May 26th, 2023

Re: Addendum #1 to 3-8-2023 Letter of Concern regarding Conditional Use Application CU-23-00001, [CU-23-00001 - 3 BR Custom Cuts - Comments Matthew Vaughan, Arrienne & Shannon Bright 3-8-23](#)

3200 Wilson Creek Road

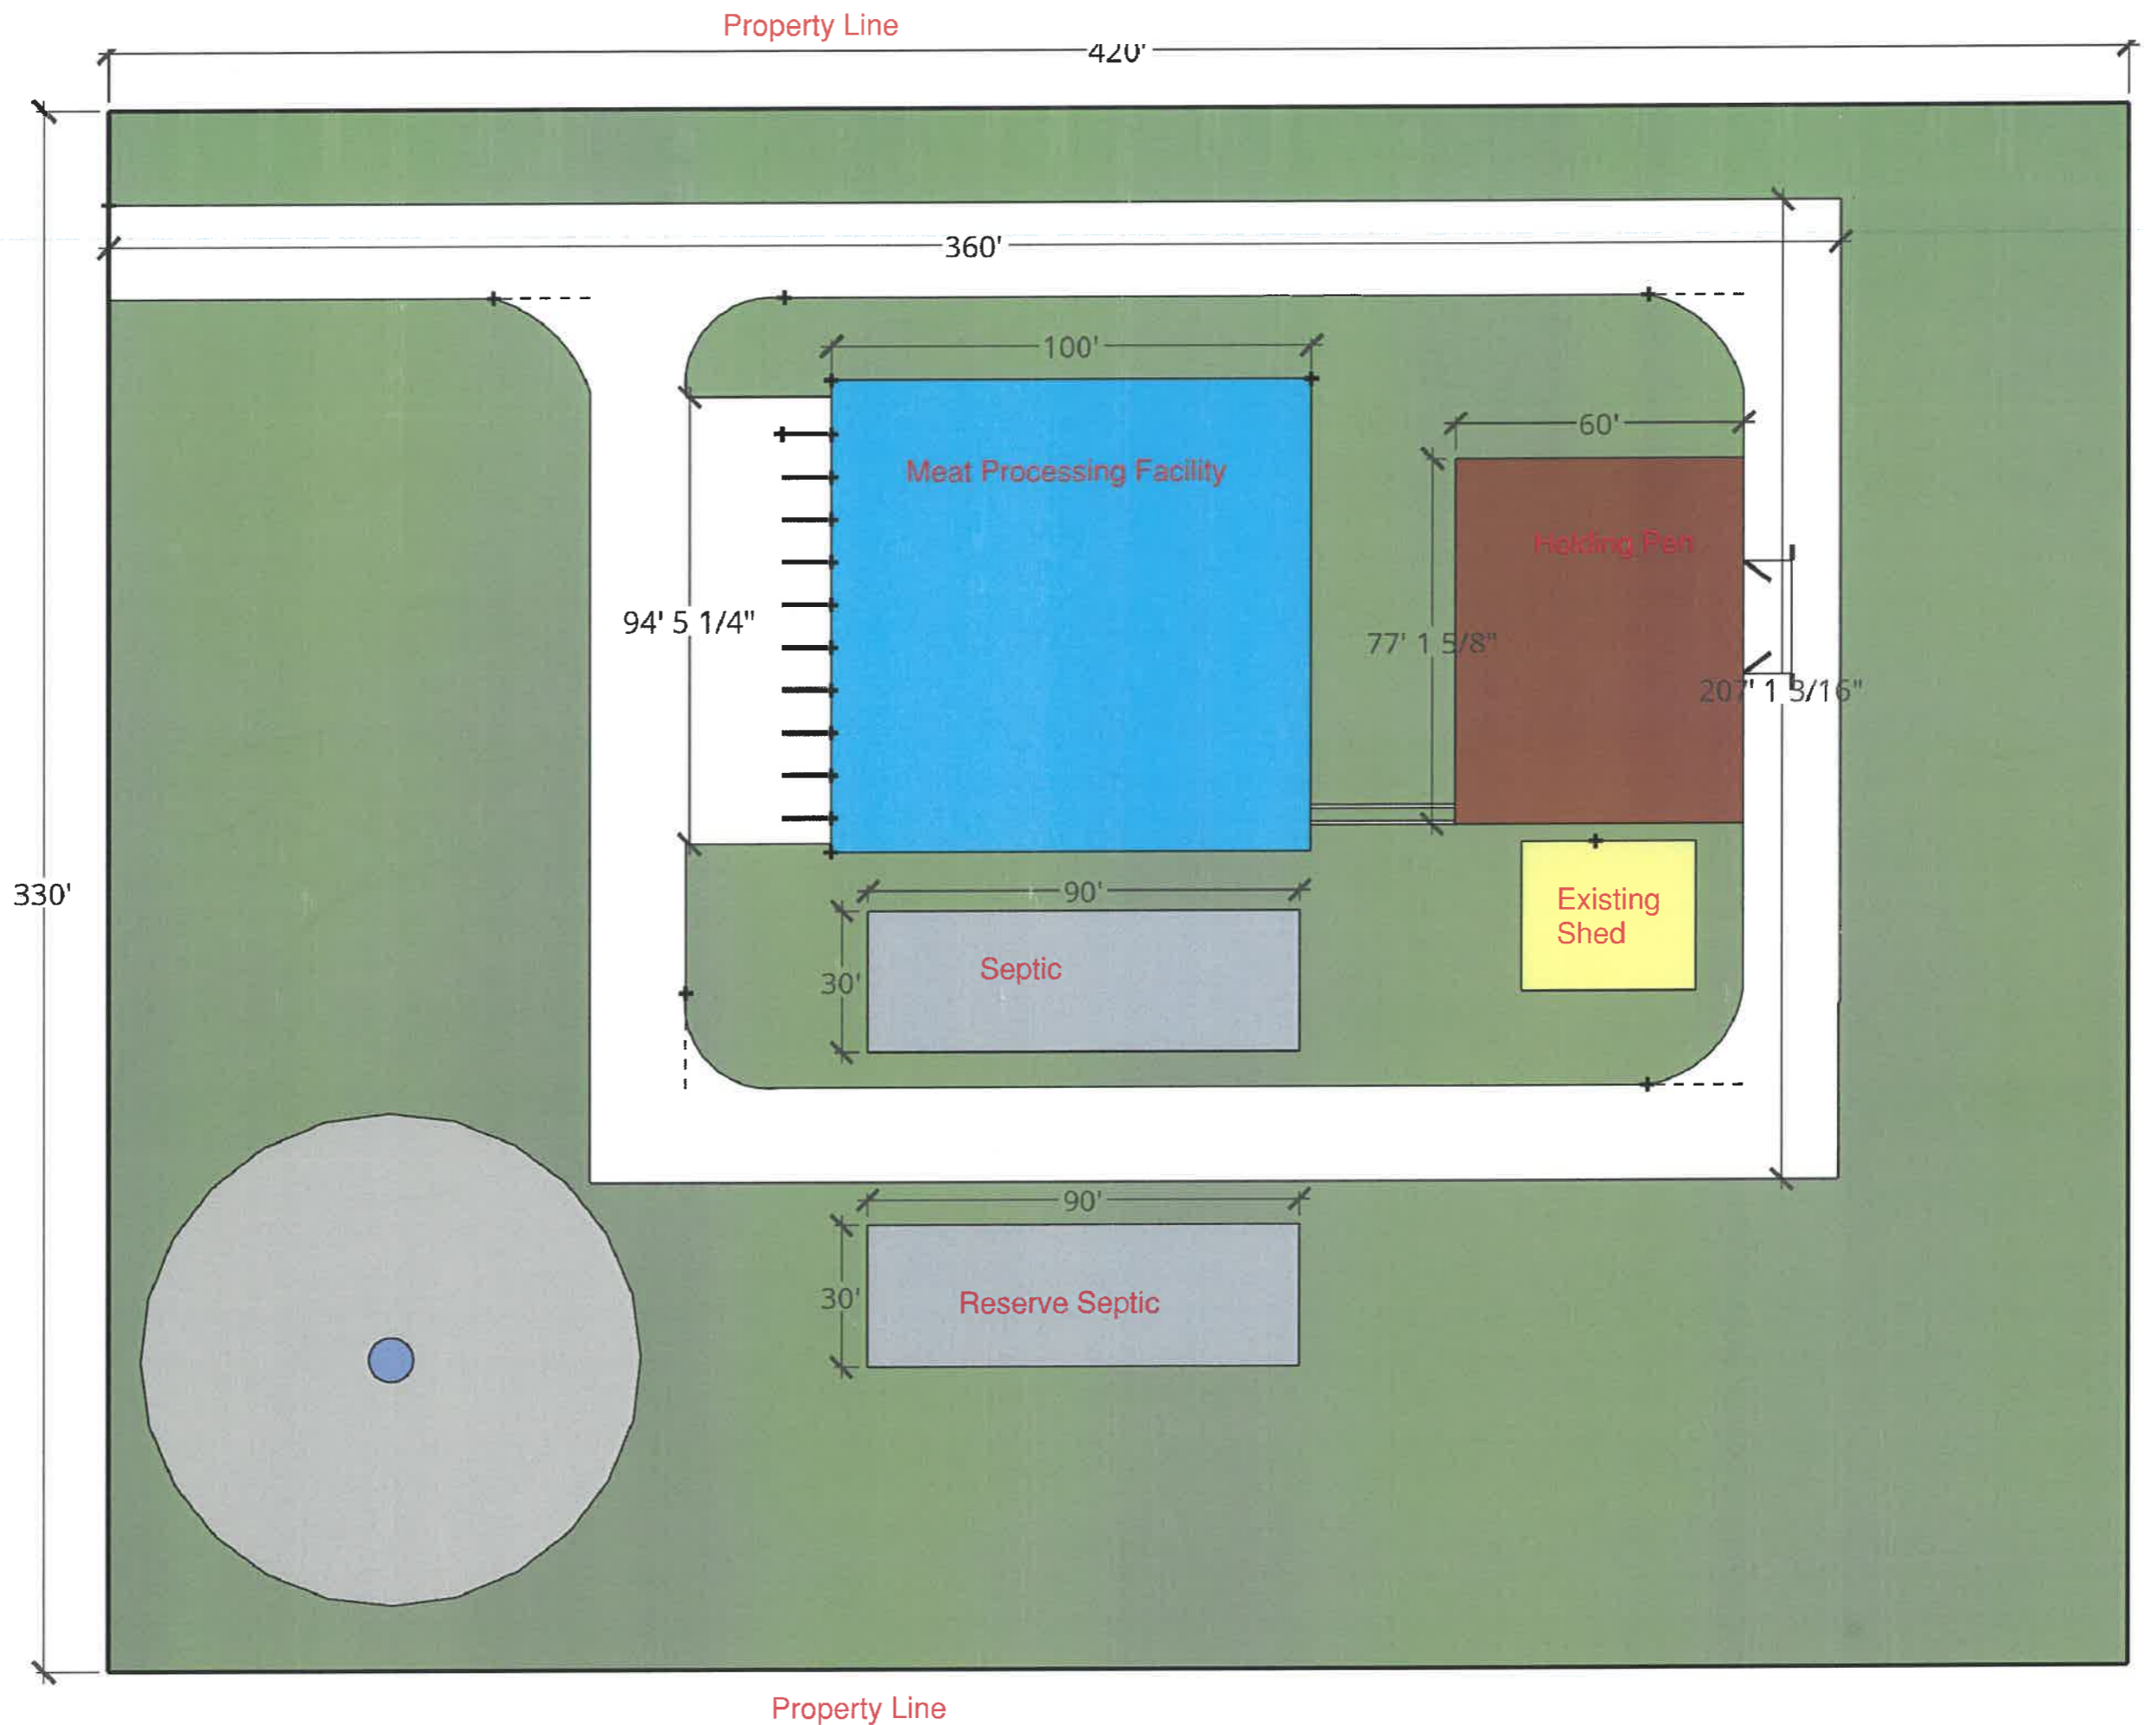
- Is the Wilson Creek Rd frontage with the sharp right angle turn onto the highway (as denoted on the site plan) sufficient for livestock trucks and the offal removal trucks to access Wilson Creek Rd—with its minimal shoulders, its 50mph speed zone—without encroaching into oncoming traffic and/or impeding the flow of traffic posing a potential threat to public safety?

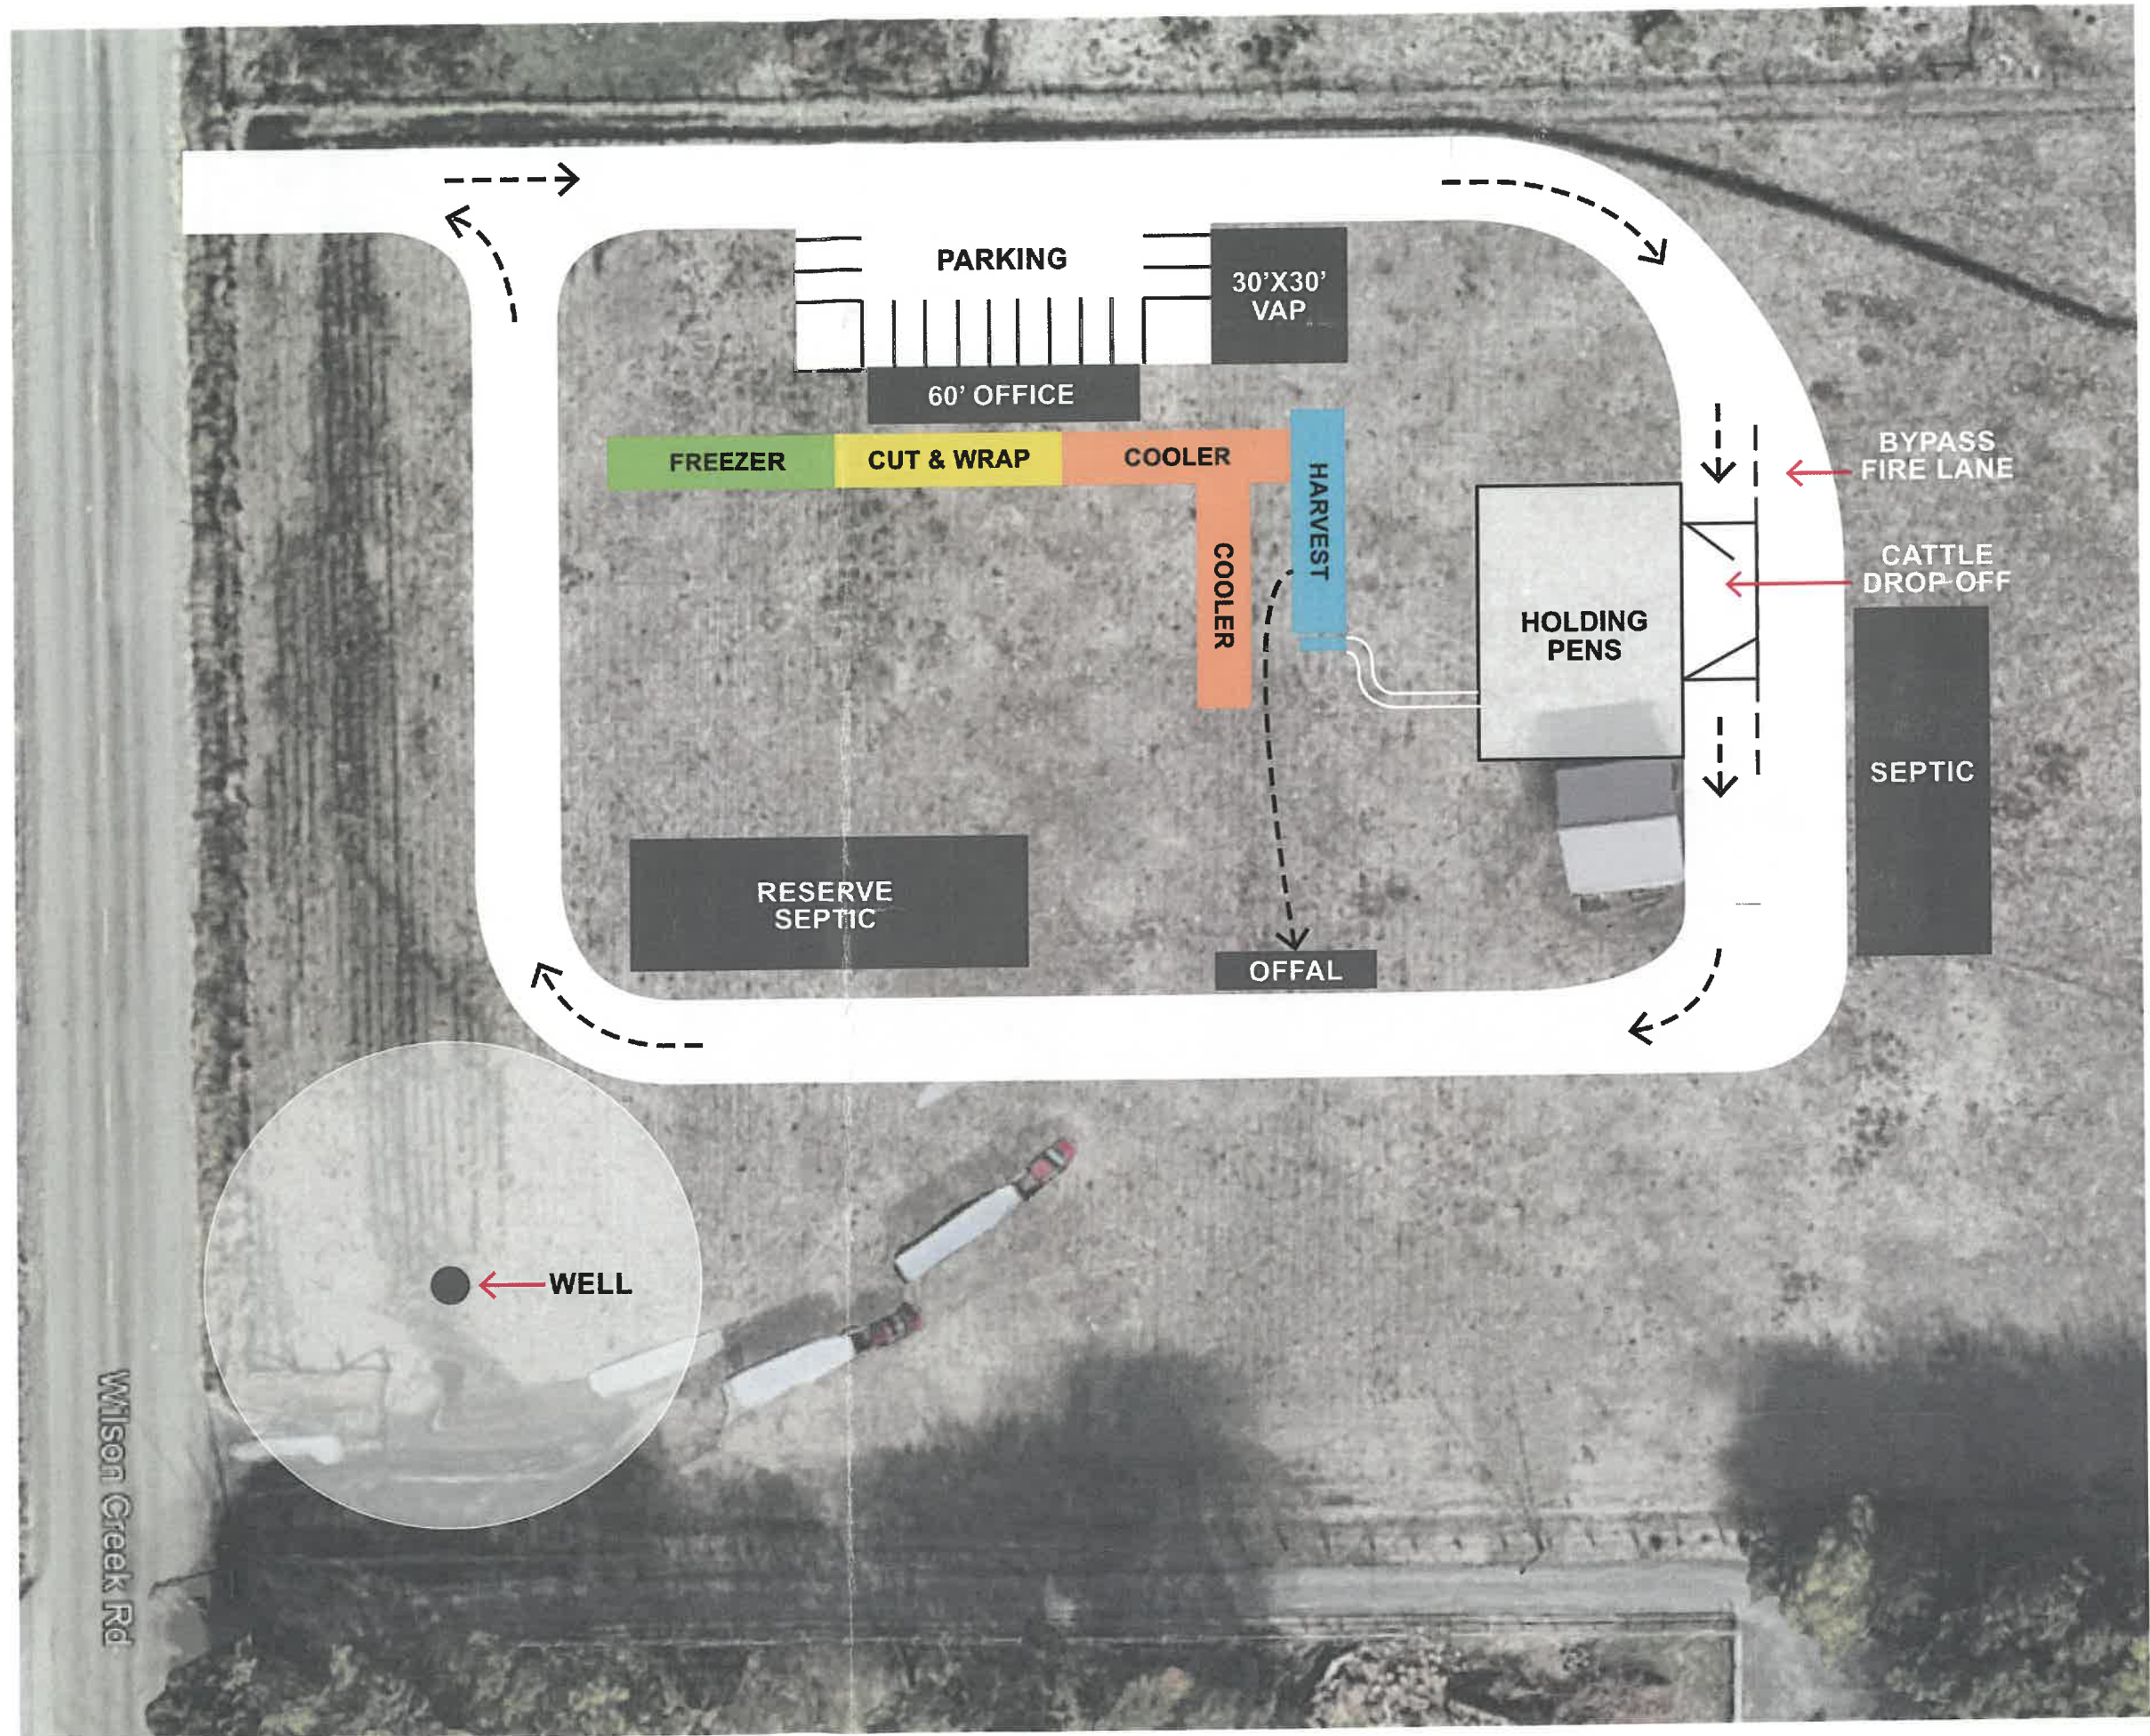
The trees they intend to plant on the West and Southern boundaries of the property will do little to "mitigate the material impacts of the development..." and there appear to be no trees planned for the northern boundary. The site is "incompatible with the existing neighboring land uses." Given the fact that the meat processing industry is noted for having significant collateral negative aspects and the fact that the site plan depicts a density of buildout concentrated on the western 400' of the parcel, it is clearly not in keeping with the "rural character" of the area and trees on two sides the parcel will not mitigate this disruption.
